Application No: Y/36/22/HH

Site Address: Berri Court Main Road Yapton BN18 0ED

Description of works: Erection of detached workshop, gym/hobby and greenhouse. This application affects character and appearance of the Main Road/Church Road Yapton Conservation Area and a Listed Building.

Response to Y/36/22/HH

South Elevation scale 1:50

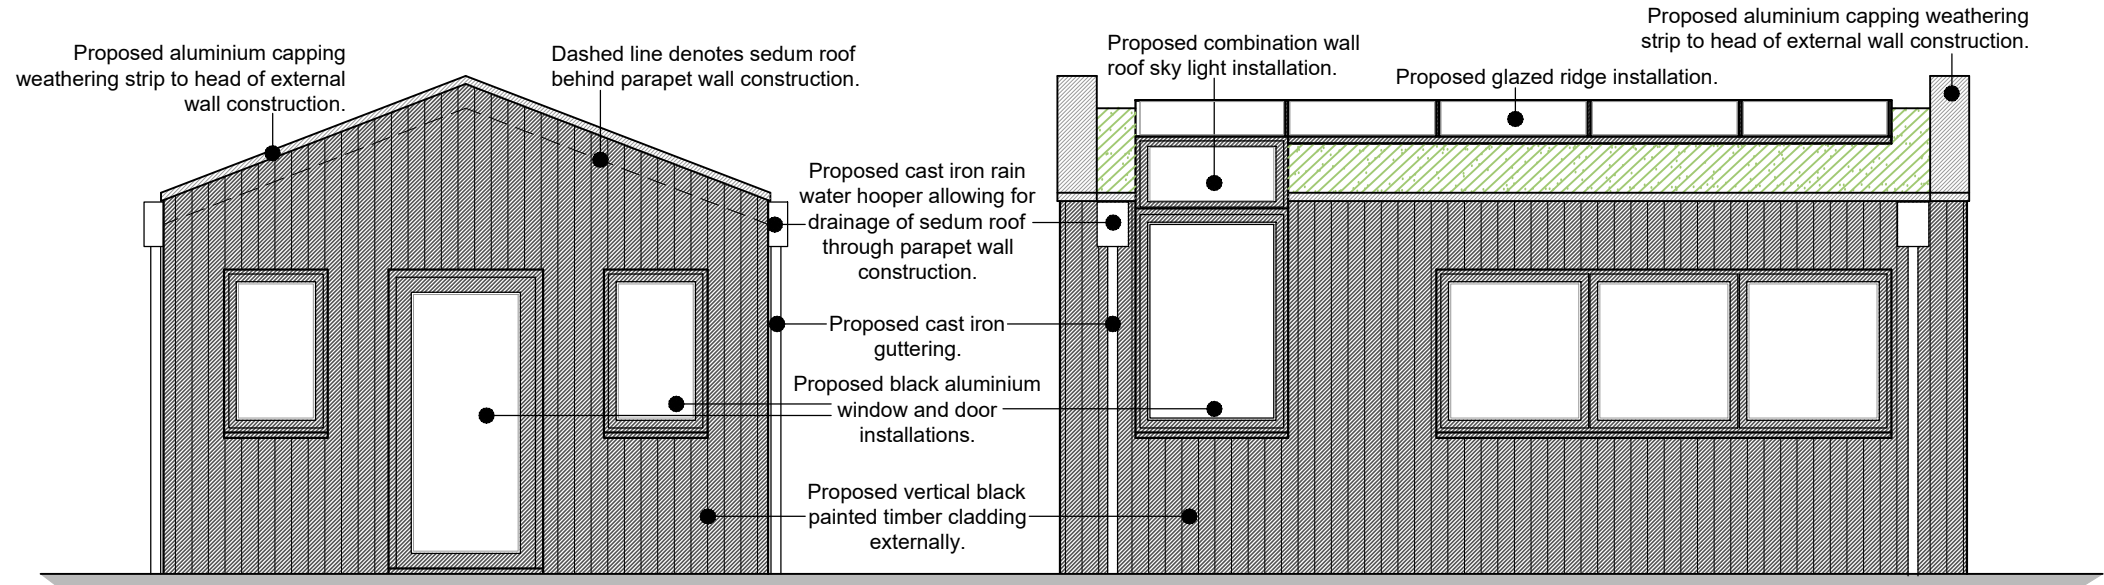
3. Proposed gym/hobby room (drawings BR/497/05) - The proposed building is identical to the proposed workshop. Whilst to the back of the Berri Court the proposed building is sited within an interesting historical

backdrop to the listed building. YPC believe that the proposed unit must be more reflective of the character and heritage of Berri Court. YPC would also expect an additional outbuilding in this area to relate more closely with the main dwelling. It should also be noted that due to level differences this proposed building will stand higher than the proposed workshop thus having a wider impact on the wider conservation area and adjoining properties.

TITLE NATIONAL TRUST GREENHOUSES THE WIMPOLE WITH SPECIAL BENCH. (NT-WIMP-ST-R-D-C-X-RAL 9005)		
DRAWN LC	DATE 23/02/22	SCALE 1:50 @ A3	DWG NO. NT/HARD30539_GP. Sheet 1 of 2	REV -
CHECKED NR 24/2/22	CUSTOMER / ORDER No. Mr Harding, Berricourt. 30539

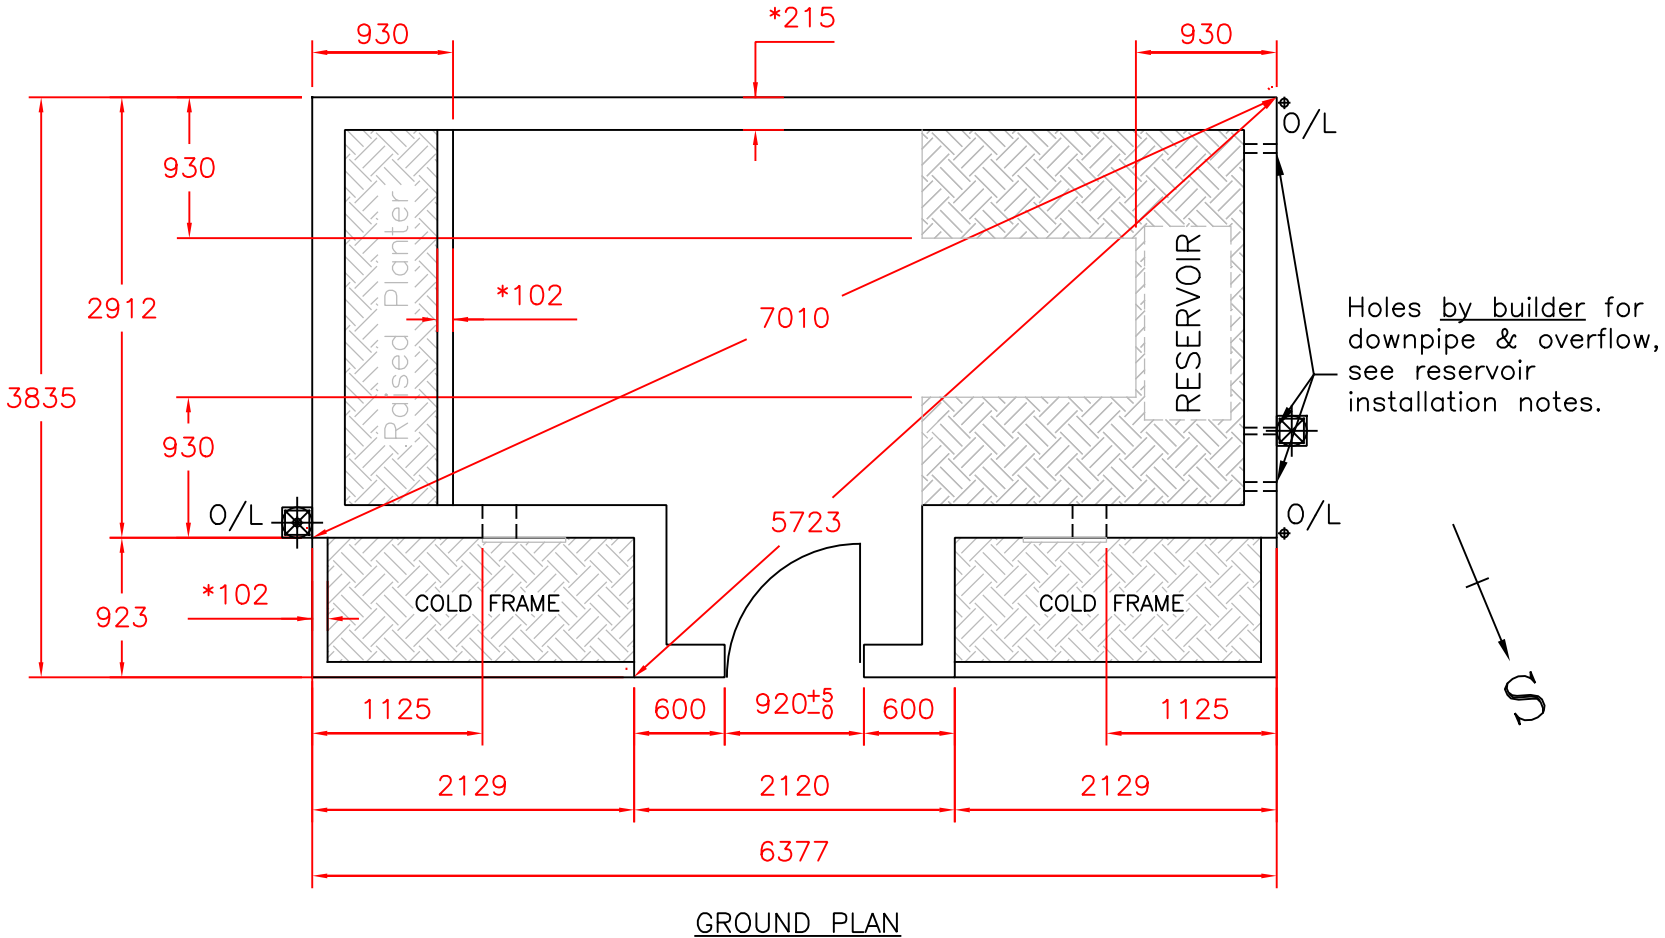
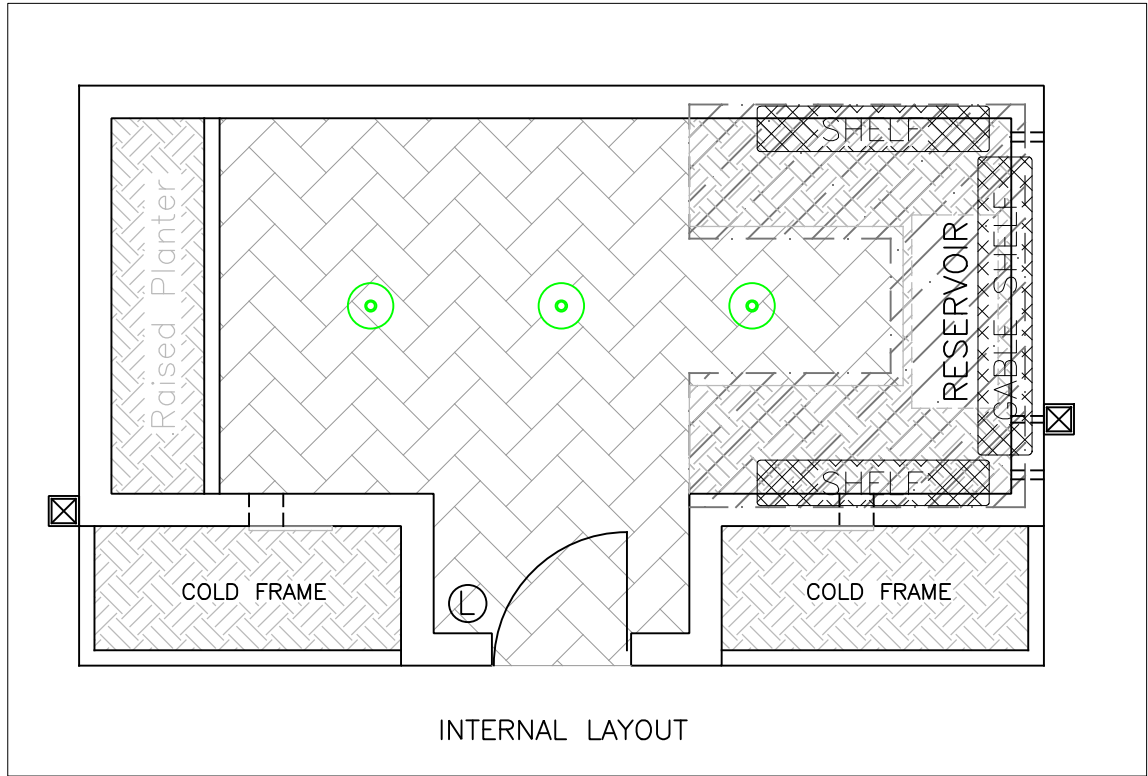
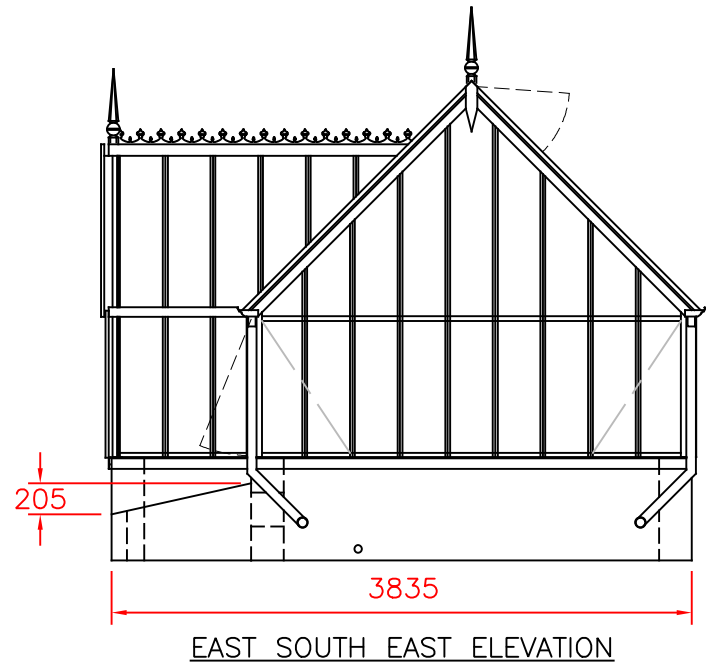
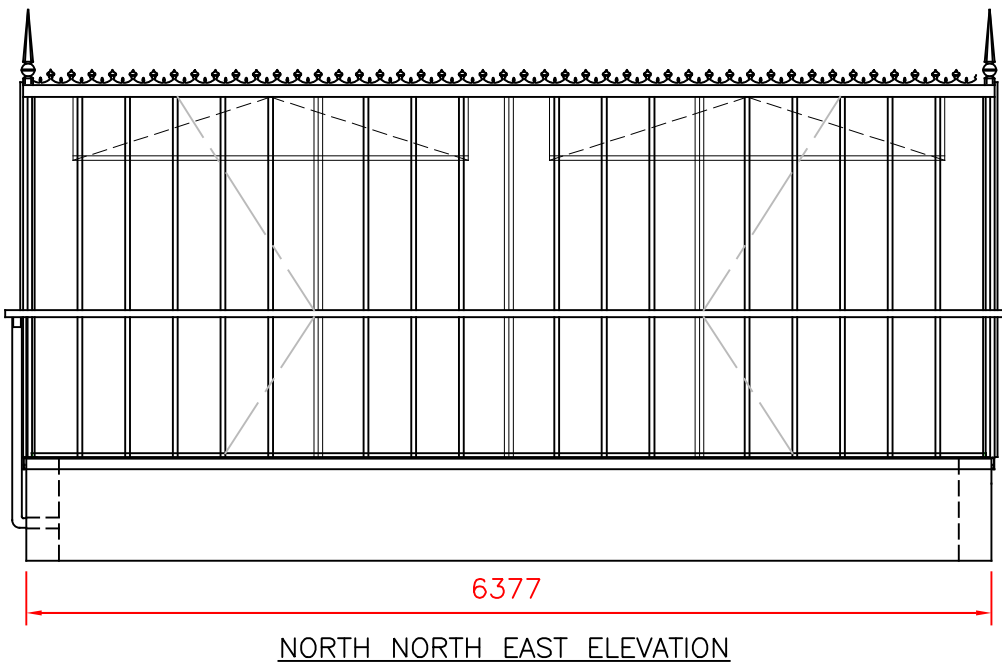
1. Greenhouse - Whilst the greenhouse is located within the near curtilage of the main dwelling, YPC appreciate that the function of the building draws on the heritage of this area of walled garden. YPC also note that the applicant has carefully considered an appropriate design and use of materials for the greenhouse to compliment the listed building.
